**From:** Brian Banister [REDACTED]  
**Sent:** 05 May 2022 10:09  
**To:** Planning.Responses <Planning.Responses@arun.gov.uk>  
**Subject:** Re: Planning Consultation on: AB/44/22/PL

**Application No:** AB/44/22/PL

**Site Address:** 2 Maltravers Street Arundel BN18 9AP

**Description of Works:** Change of use of building from residential (C3) to a mixed use of residential and art gallery (Class E). This application affect the setting of listed buildings, affects the character and appearance of the Arundel Conservation Area and is in CIL Zone 2 (Zero Rated) as other development.

PROPOSED ELEVATIONS AND SIDE VIEW

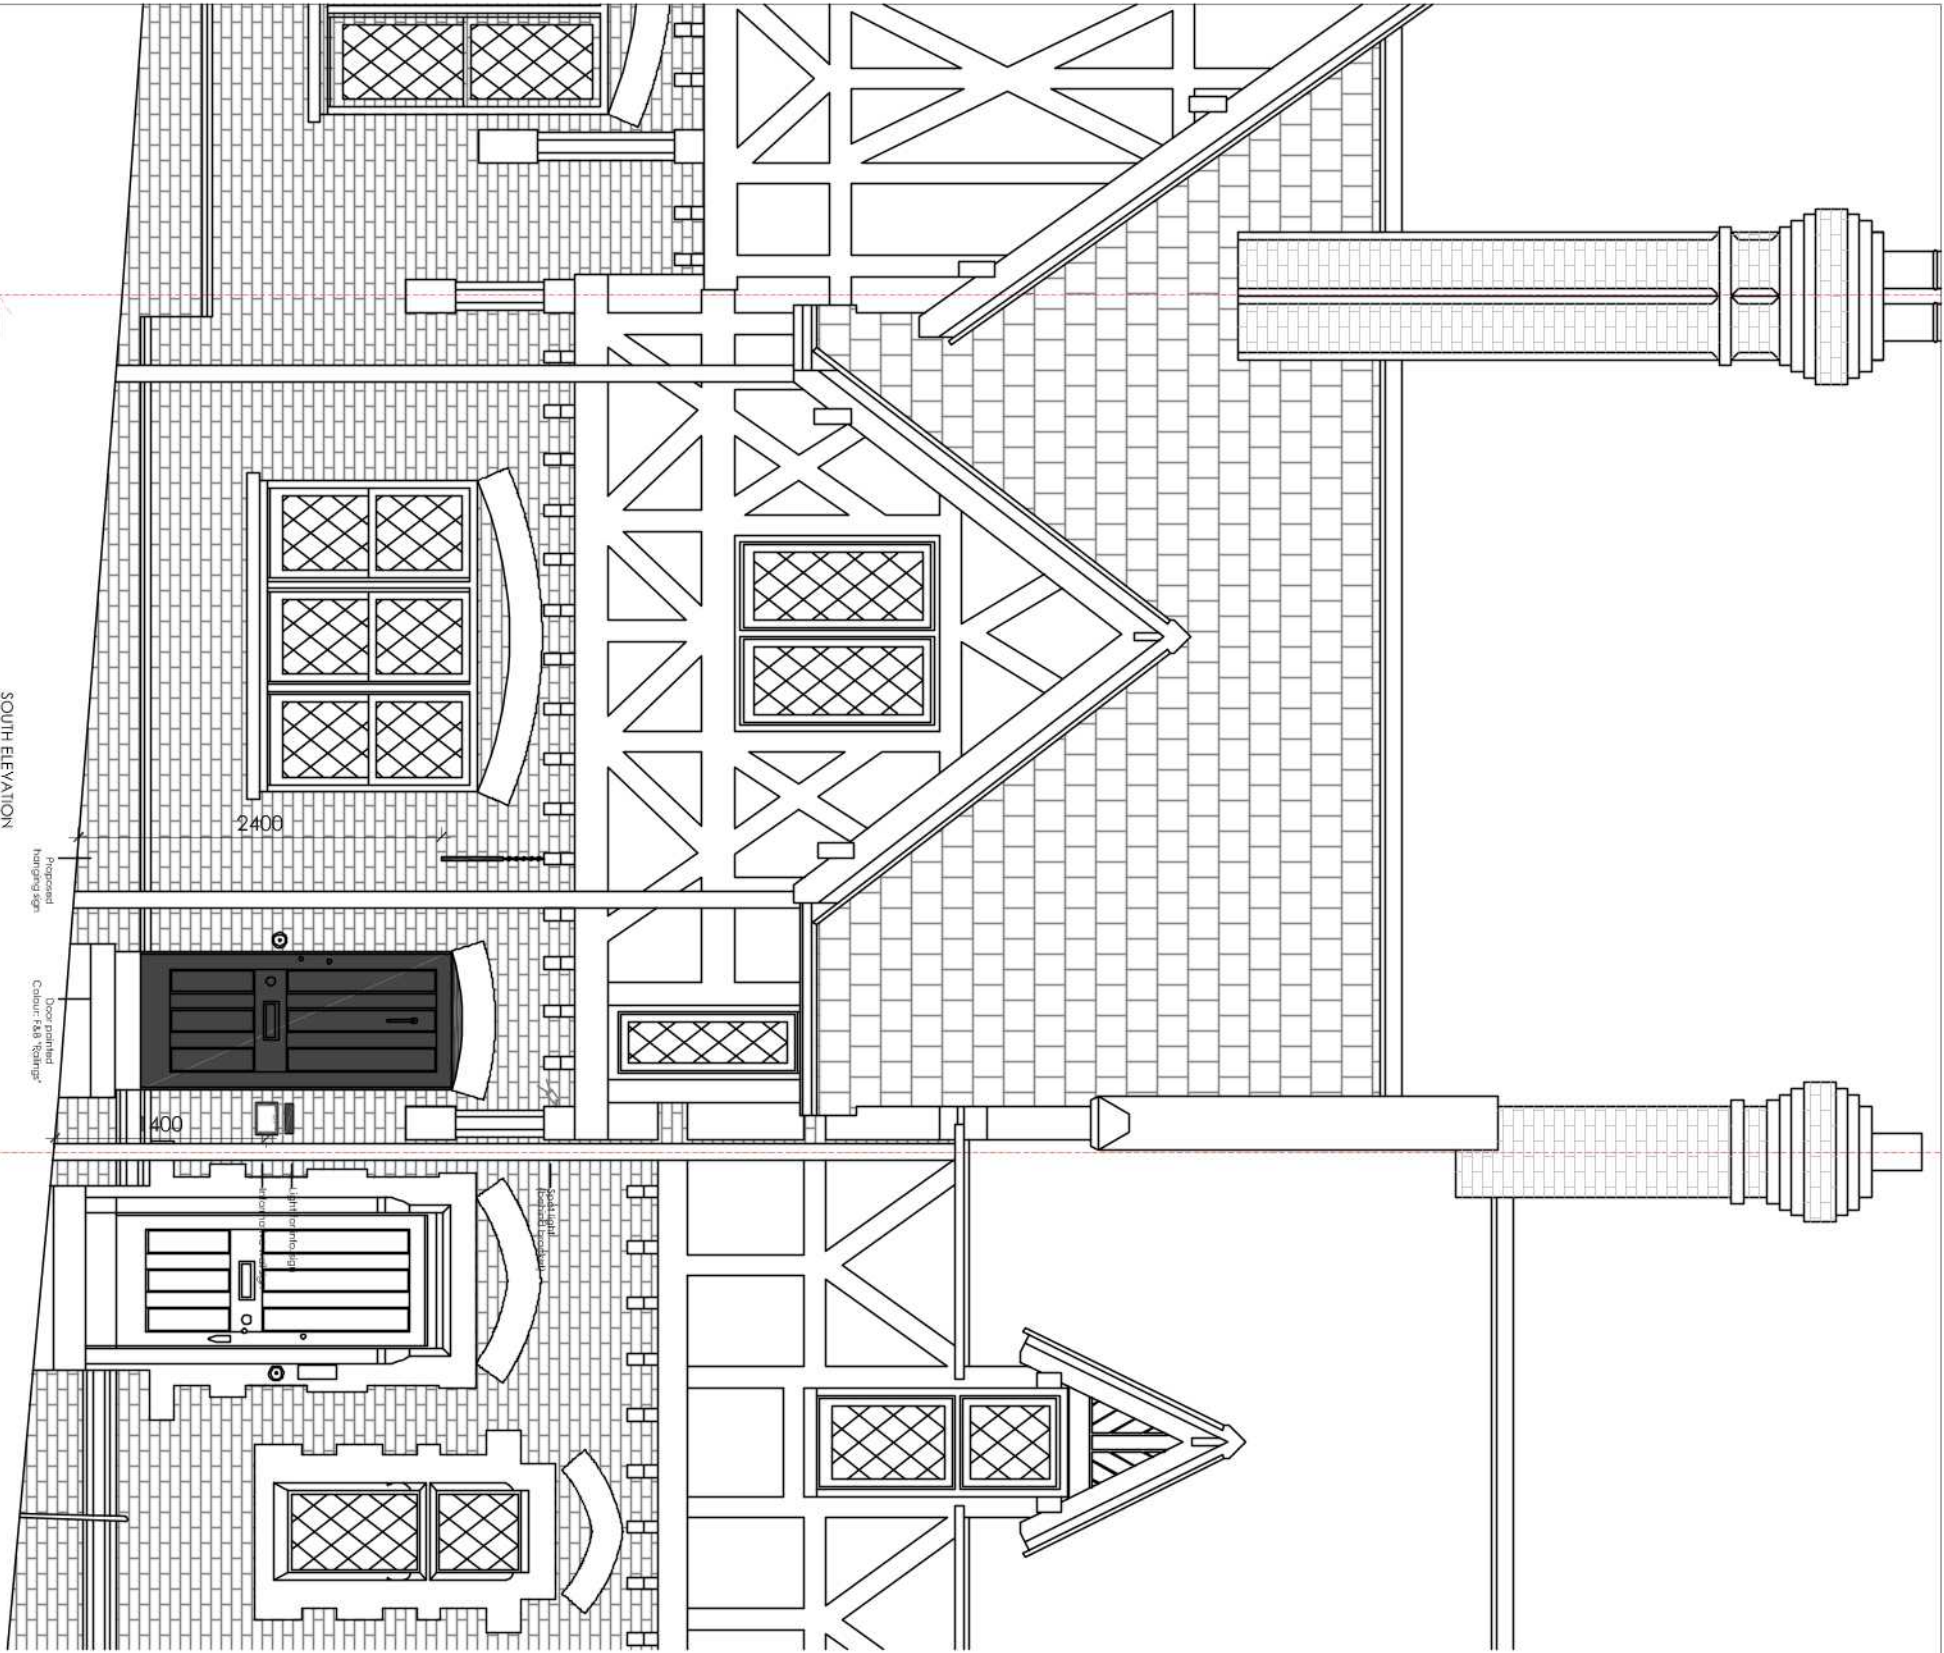
However, for the reasons explained in the application for listed building consent, the Panel does object to the painting of the oak front door but it is assumed that this particular alteration is permitted development (but that it does require listed building consent).
